# CITY OF ALBUQUERQUE

July 22, 2024

**Re: Carlisle and I-40**  
**Traffic Impact Study (H16D047)**  
Engineer's Stamp 7-1-24  
Via email BrianHoran@GallowayUS.com

The subject Traffic Impact Study (Study) draft received on July 2, 2024, has been reviewed by the City of Albuquerque Planning Development Transportation Section. The City has the following comments to be addressed.

FIGURE 1-2
SITE PLAN

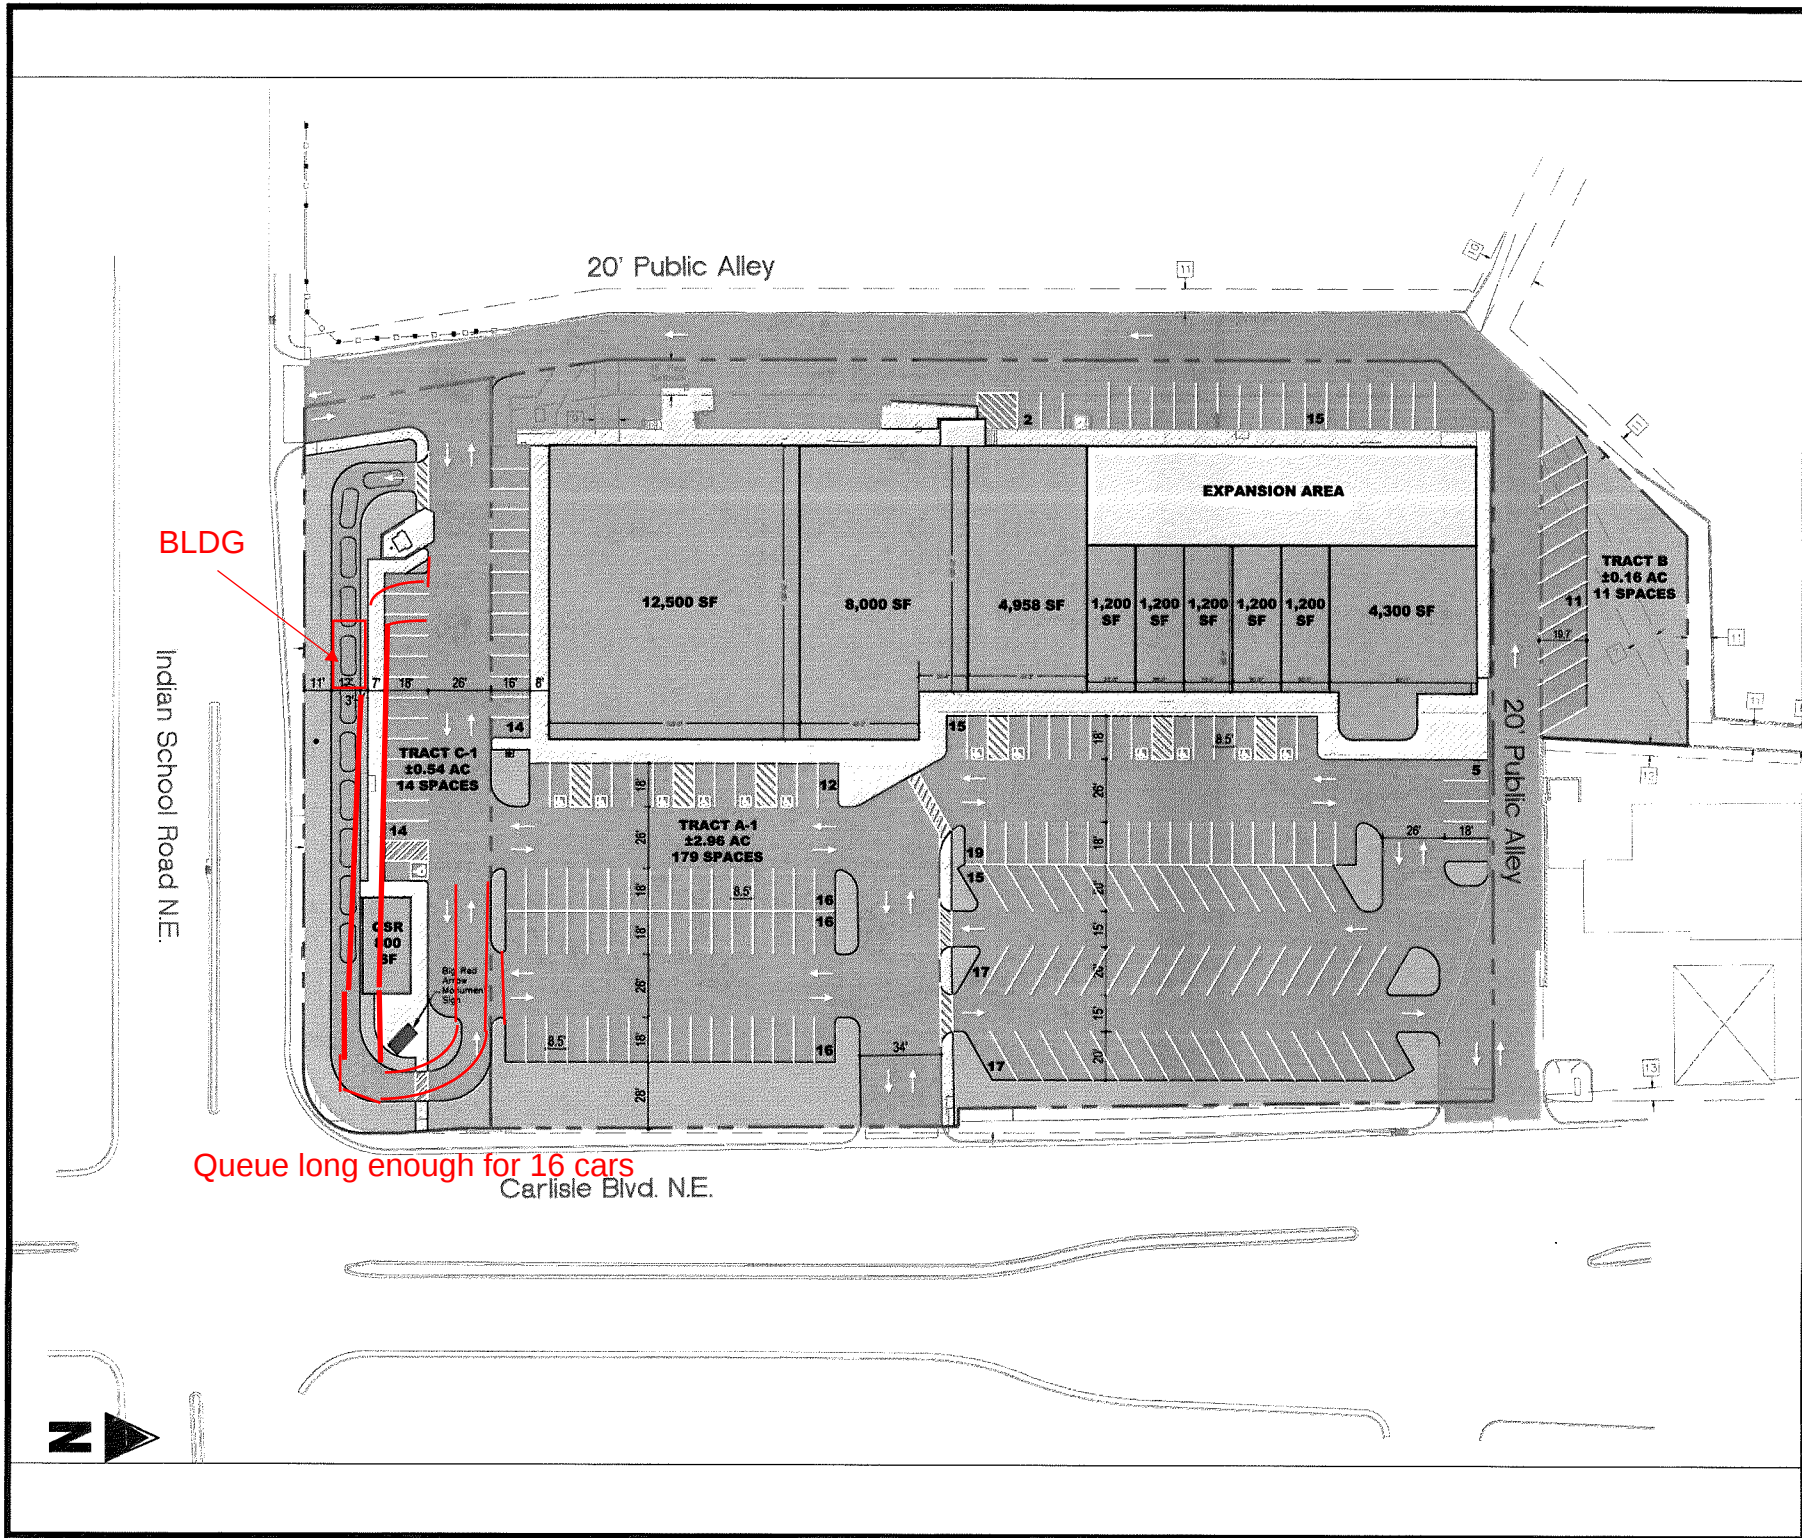
2. For the drive-through land use, the City has a minimum queue of 16 vehicles and sometimes that isn't sufficient. It is not desirable to have the queue back-up onto Indian School Rd. A meeting was held with Wes Butero on 7-19-24 to discuss the redesign of the drive-through. Include the revised Site Plan in the Study.

TRAFFIC CONTROL SITE PLAN

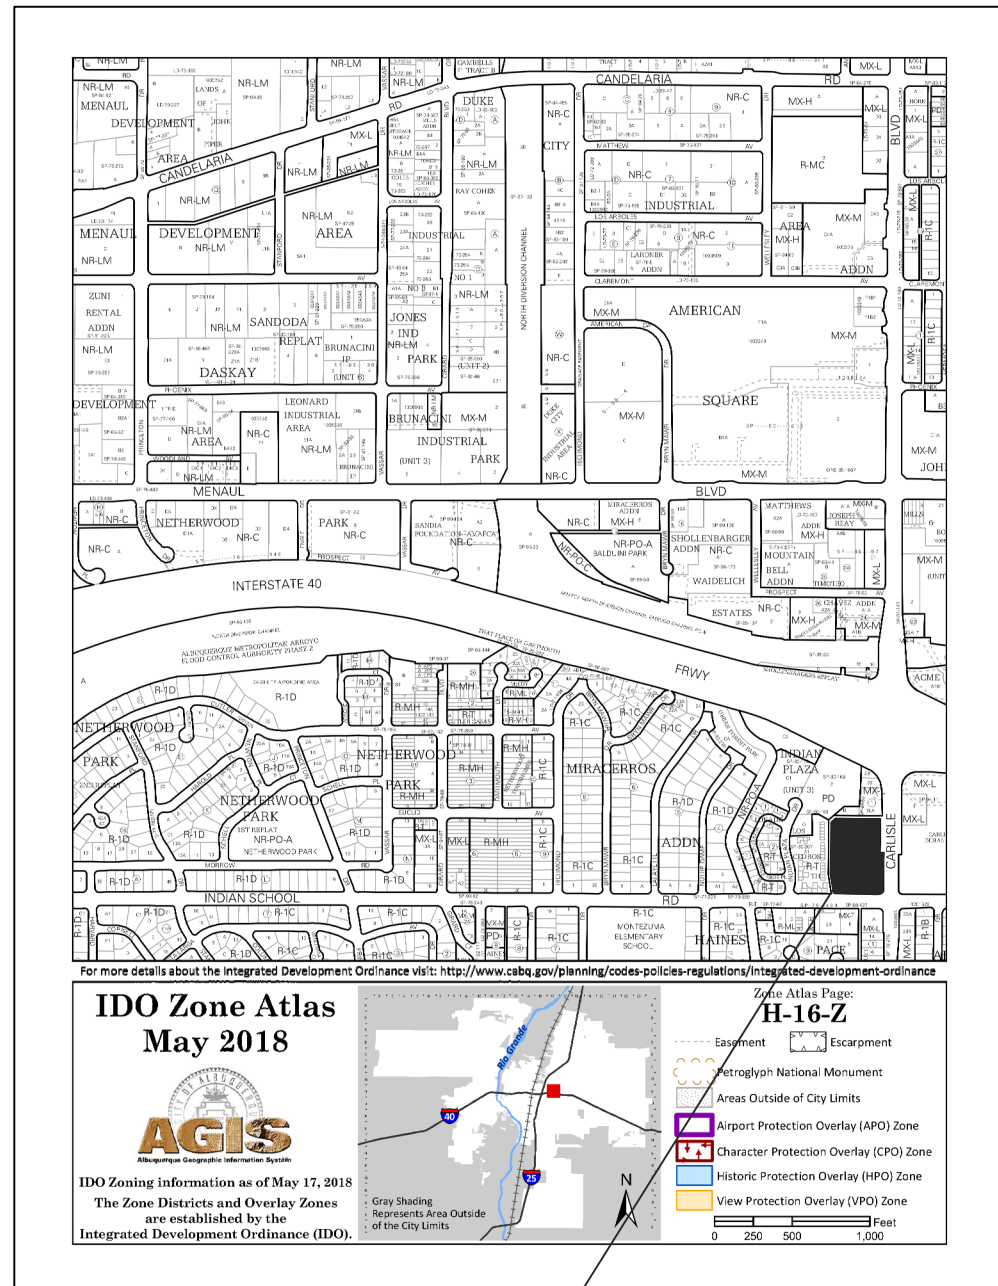
6. What is the reason for proposing the City's alley to be one-way? The 20' width is acceptable for 2-way traffic. How may this impact the use of Tract B? Is there a planned use for Tract B? If the pavement markings in the alley are approved, it seems appropriate for them to be maintained by the Owner of Tract A-1.

CARLISLE BOULEVARD NE-EXISTING CONDITION - SECTION A

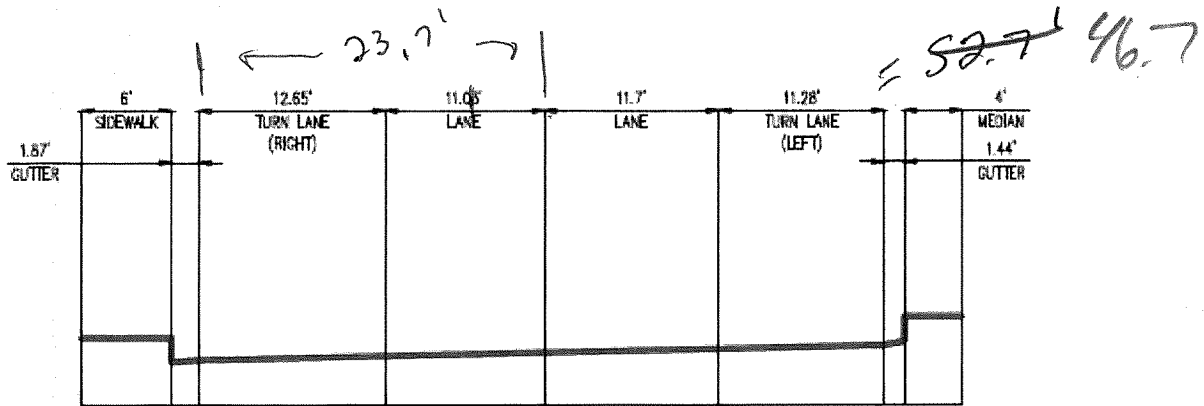
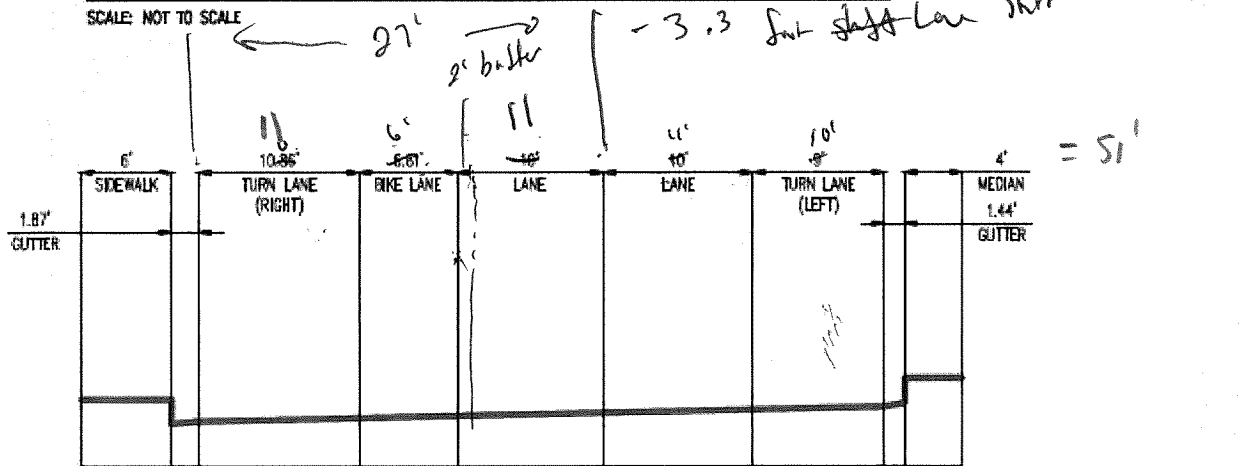
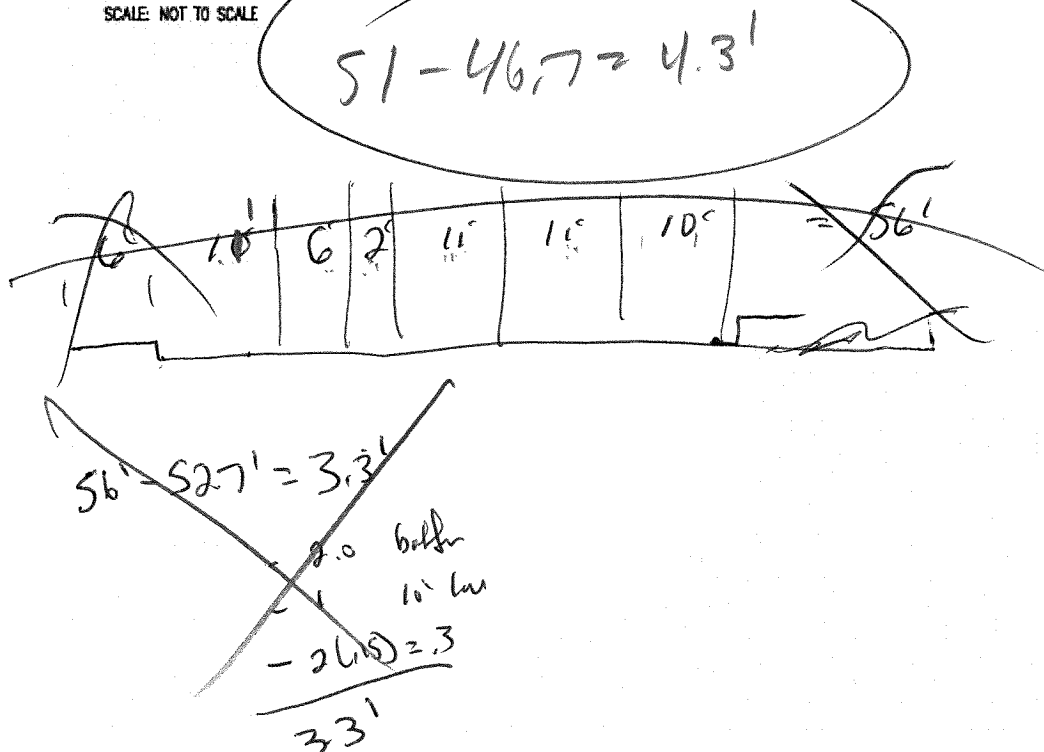
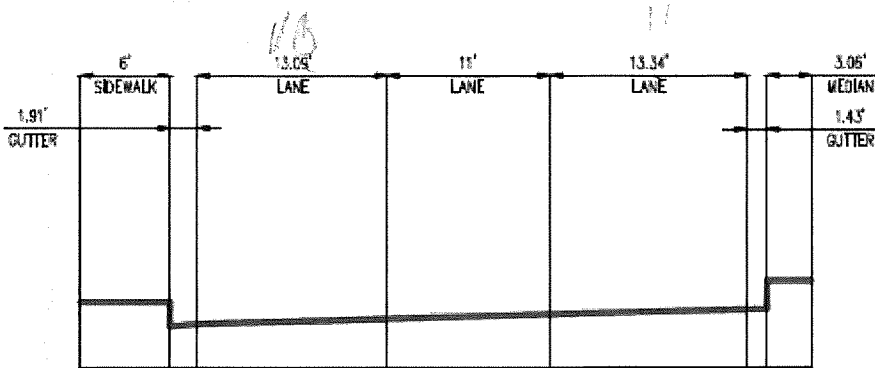
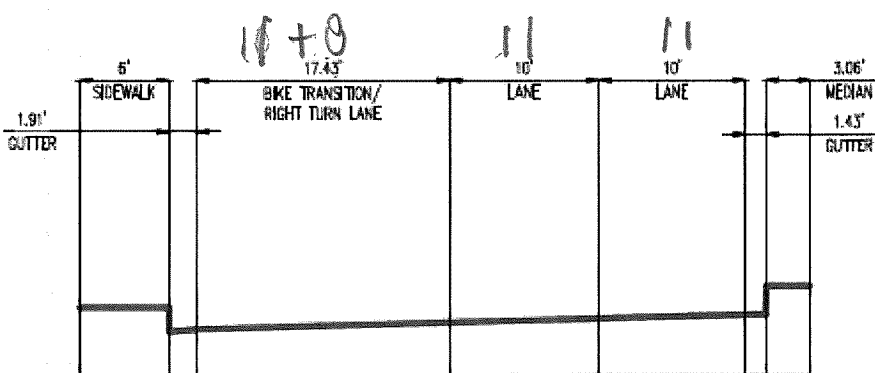
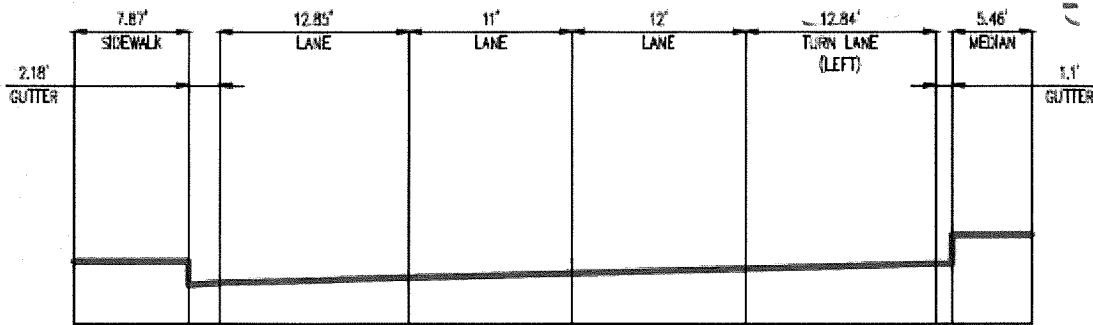
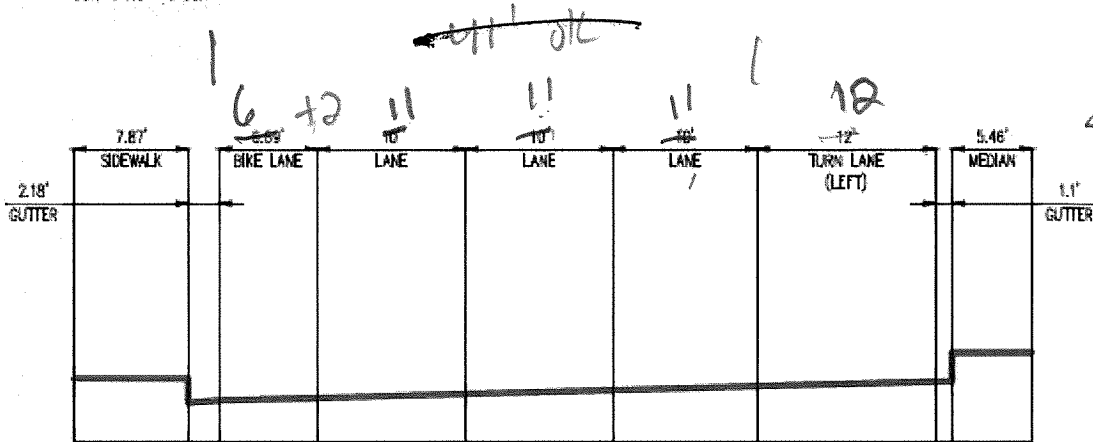
3. Include Lot B in the Study.
4. In the Recommendations section, please add the word "buffered" in front of "bike lane".
5. Provide an exhibit with a plan and section of Carlisle Blvd that shows the existing and proposed striping. The curb fronting this development may need to be relocated to the west to accommodate the bike lane. This may change the recommendation for the sidewalk on Carlisle Blvd to remain.
